RE: Durango, Unit 2

RE: Request for a Minor Amendment to a Site Plan for Subdivision – DRB

RE: Proposed Minor Amendments – Durango Subdivision

I have reviewed the application materials for the proposed minor amendments to the Durango Site Development Plan for Subdivision (2015, DRB final sign-off). I have a few questions and am requesting clarification regarding the following items:

ADMINISTRATIVE AMENDMENT

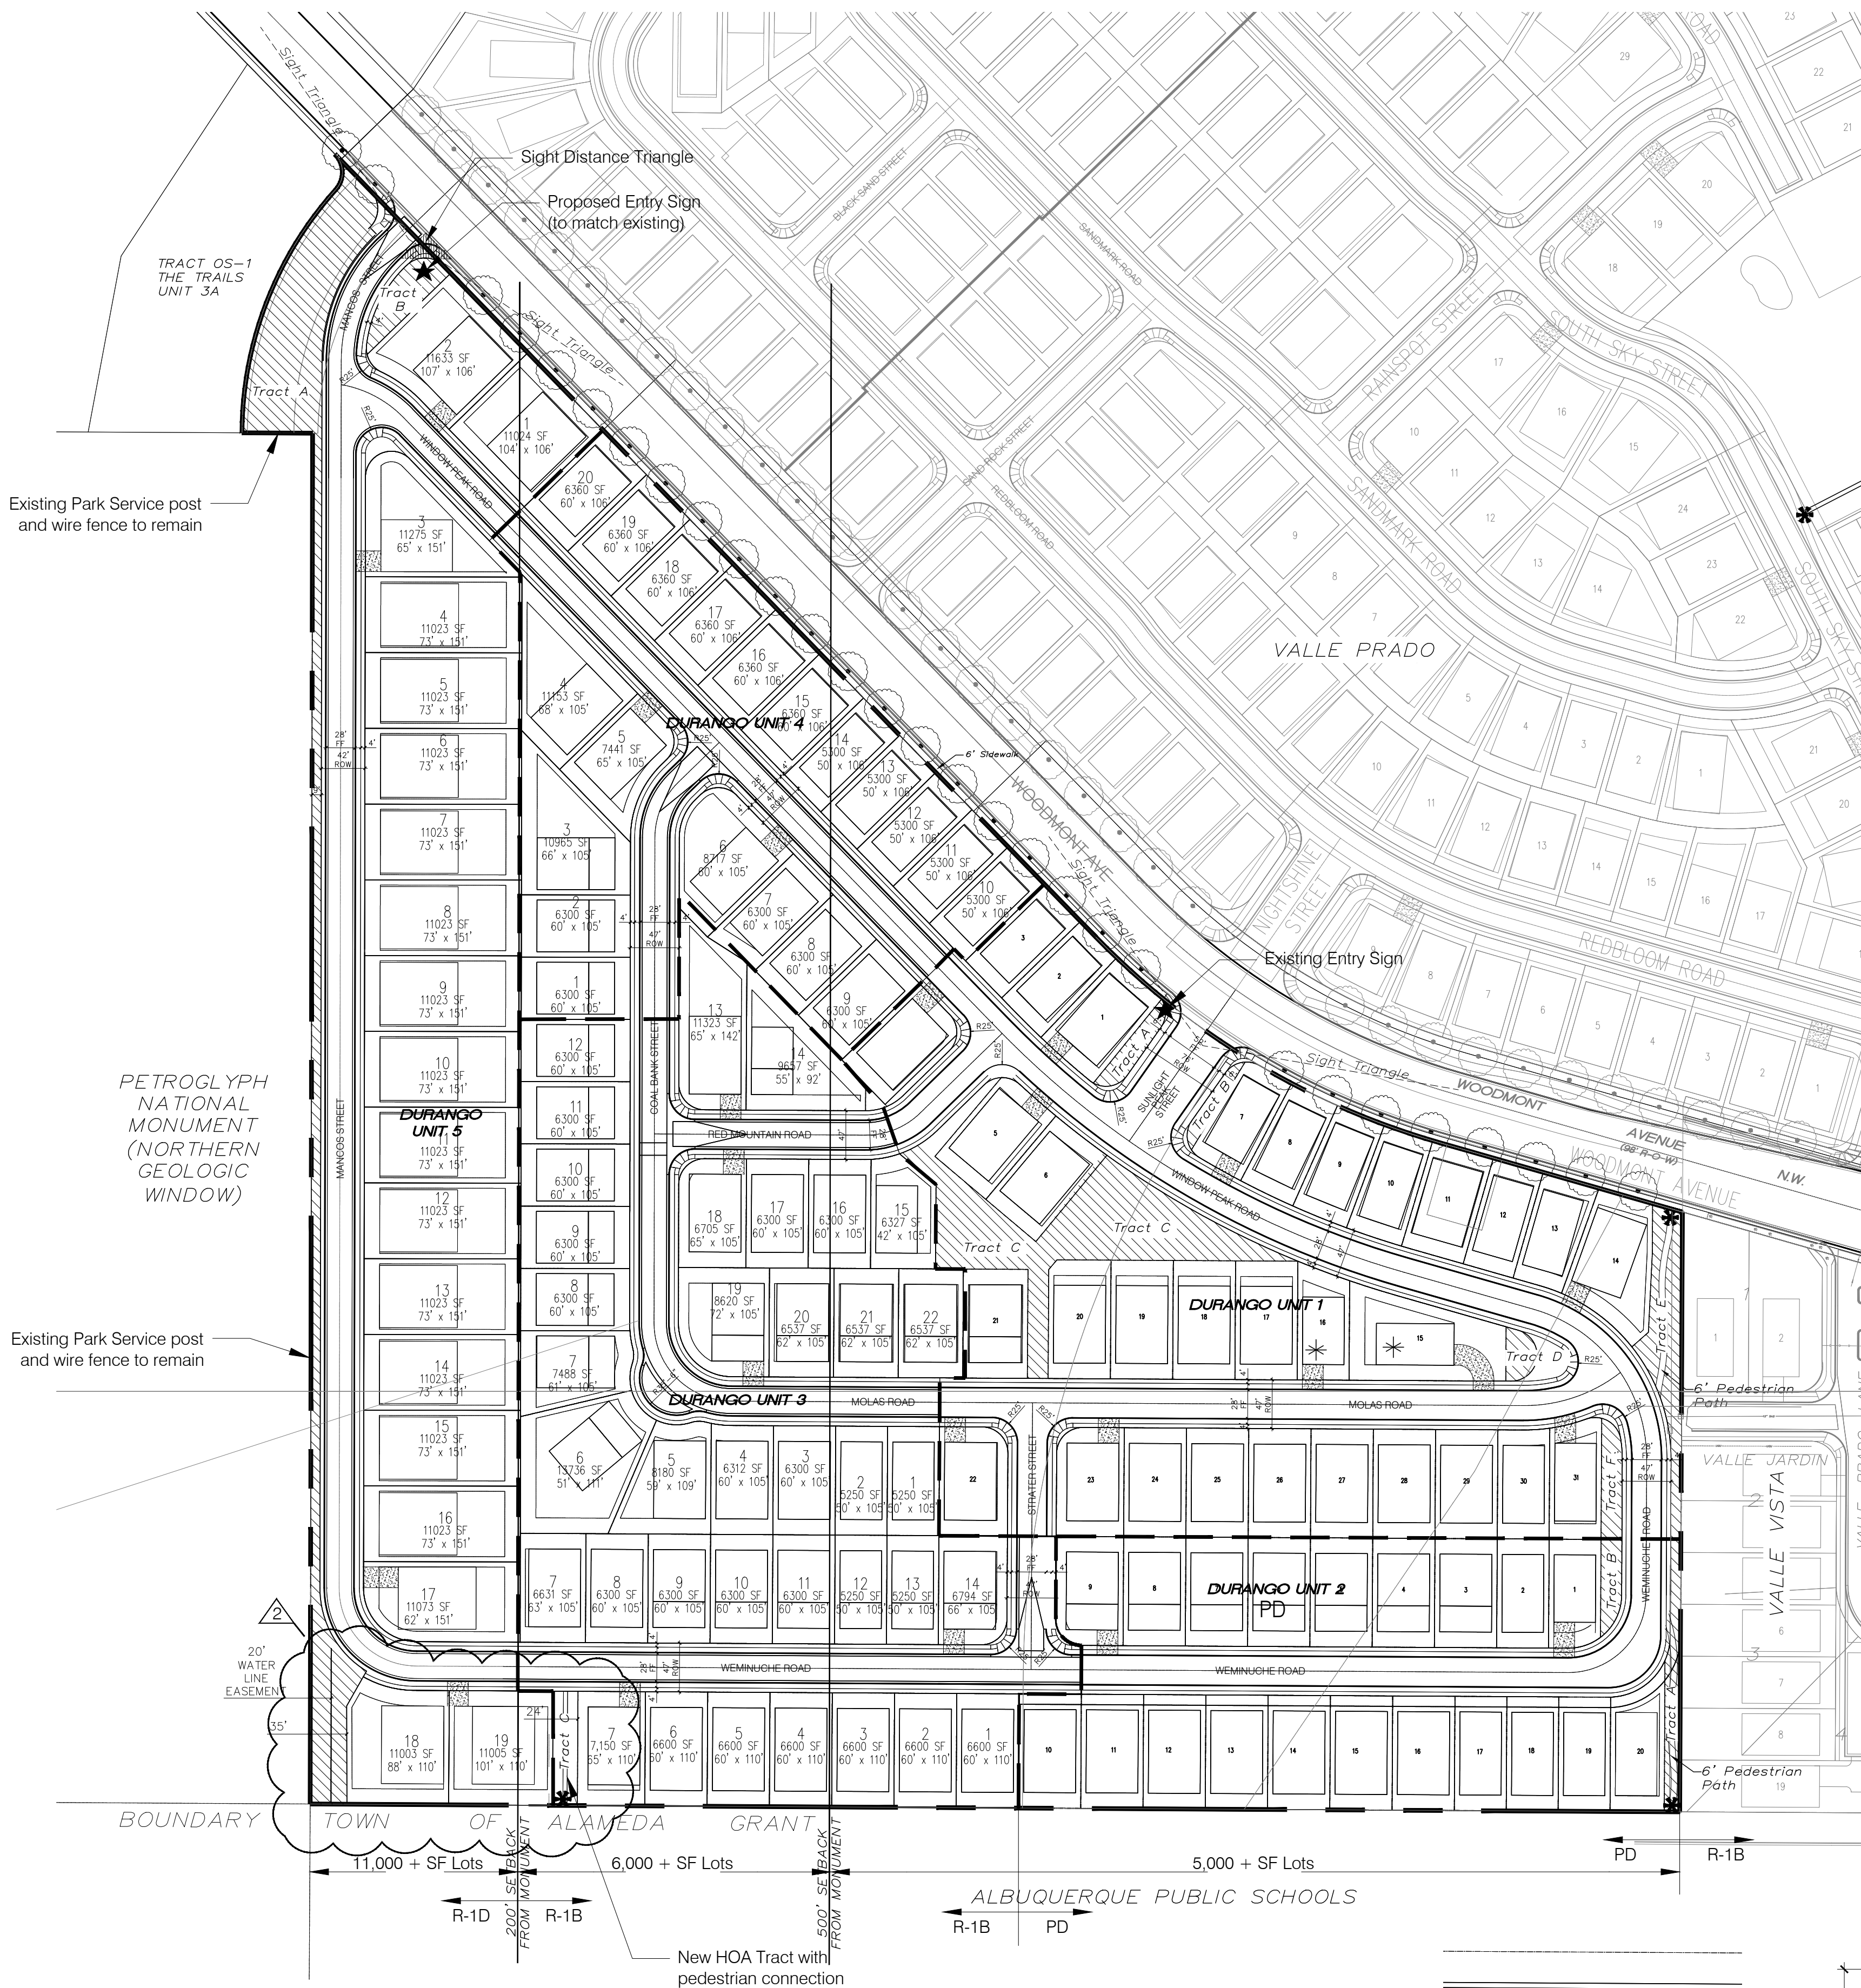
- A. How is the proposed increase in total lot square footage being achieved? The current vs. proposed site plan drawings appear to cover the exact same area.

There have been several changes to pedestrian circulation and access over time, such as the removal of the pedestrian trail along the Monument (western) side. Please explain the effect of the currently proposed removal of the pedestrian connection along the subdivision’s eastern side.

Response: The increase in total residential lot square footage is due to the removal of Tract A and B, previously HOA tracts. Unit 2 remains the same acreage overall, however, due to the removal of the HOA Tracts, additional residential lots were added increasing the total number of lots within Unit 2 from 20 to 22 and the Durango Subdivision from 127 to 129 (<2%) as a whole.

Response: Pedestrian access to the subdivision is achieved through Tract C, which is located to the west of Unit 2. The 2020 amendment added HOA tracts, which replaced Hillerman Street to provide pedestrian connection to the adjacent Tierra Antigua Elementary School campus. The old pedestrian access point via Tracts A and B was removed at the request of Albuquerque Public Schools, which preferred the new access (Tract C) as implemented with the 2020 amendment. Pedestrians will access the school from the subdivision via Tract C and access Woodmont Avenue via the pedestrian access point at Weminuche Road.

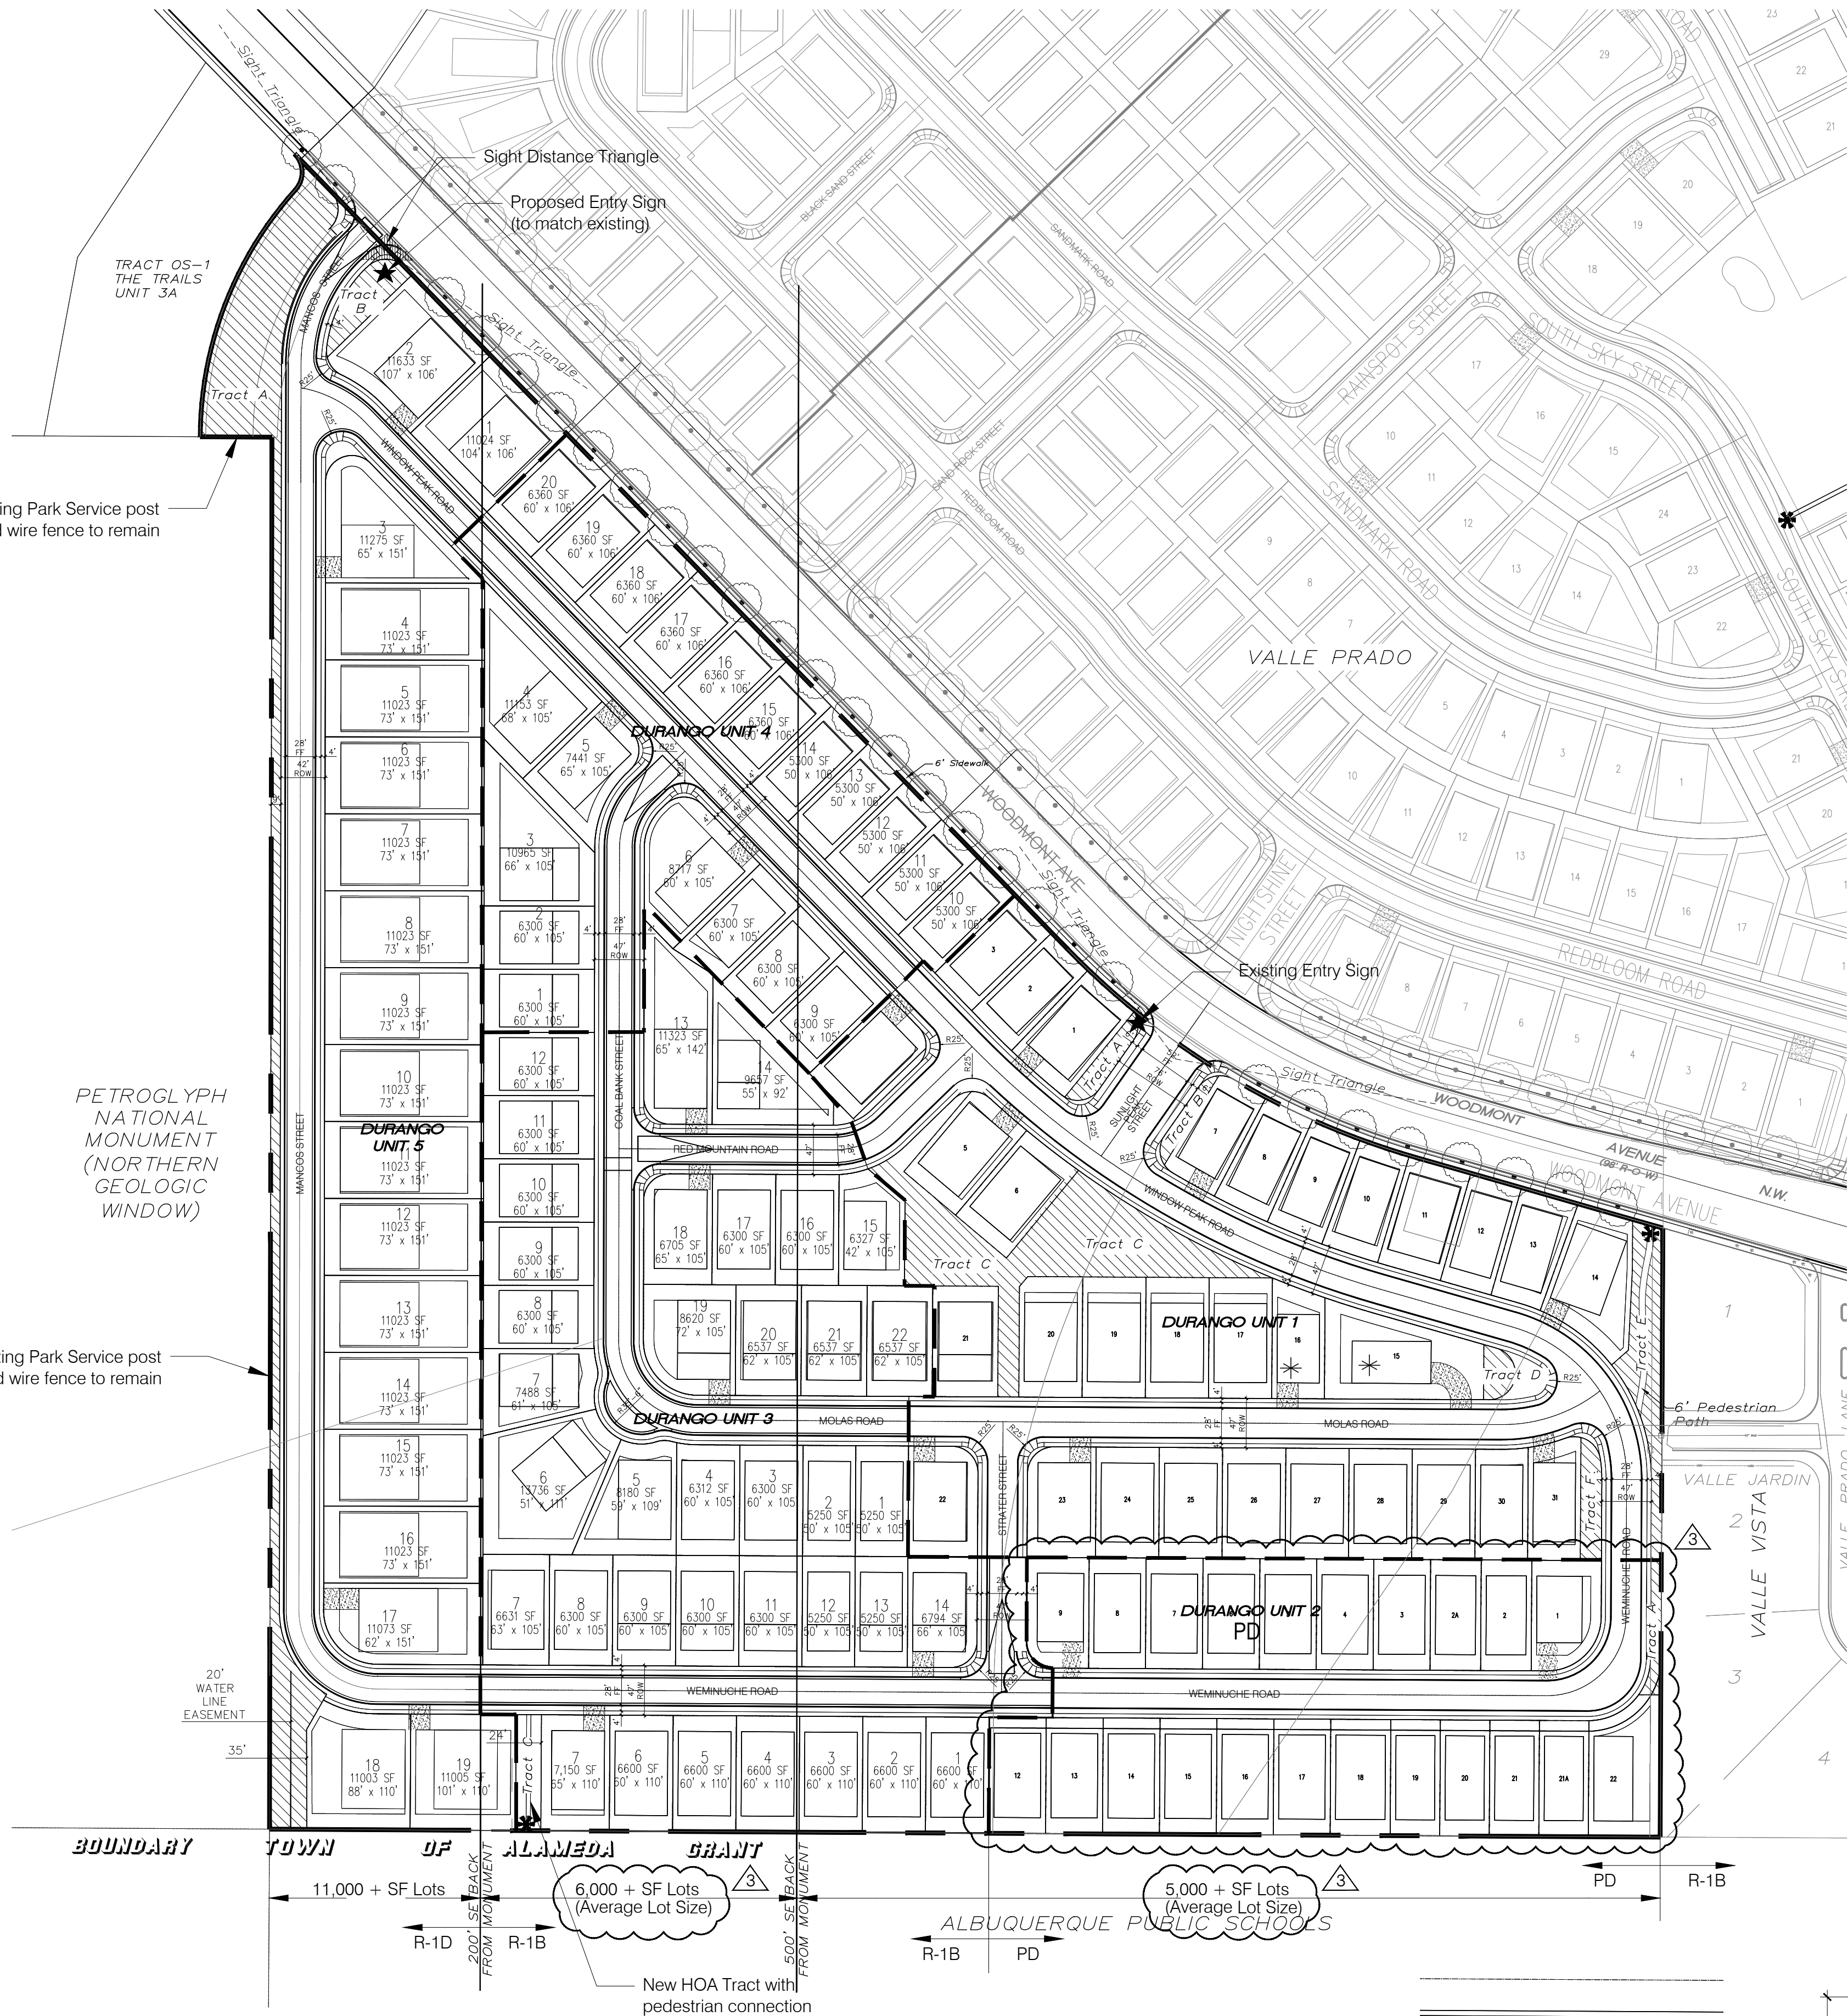
- A. One note in the keyed notes 3 group refers to the removal of HOA tracts A and B, and then says “No HOA. However, a new notes regarding the proposed Tract F states that it would be a new HOA tract”. These notes seem contradictory. Is there an HOA? Who owns these tracts, both in the past and in proposed conditions?

- B. Was the new Tract F HOA tract public before? Is it planned to be gated?

Response: This amendment does not include Tract F. It appears this comment is referencing Tract C. Originally Tracts A and B were intended to be HOA tracts within Unit 2. The homebuilder will not have an HOA for Unit 2. The acreage from the removed Tract A and B was used to create two additional residential lots. Tract C is an HOA lot, owned and managed by the HOA in Unit 1.

Response: Tract F is not part of this application. Tract C is owned by the Unit 1 HOA, it was not previously a public tract. It is gated for pedestrian use by the residents.
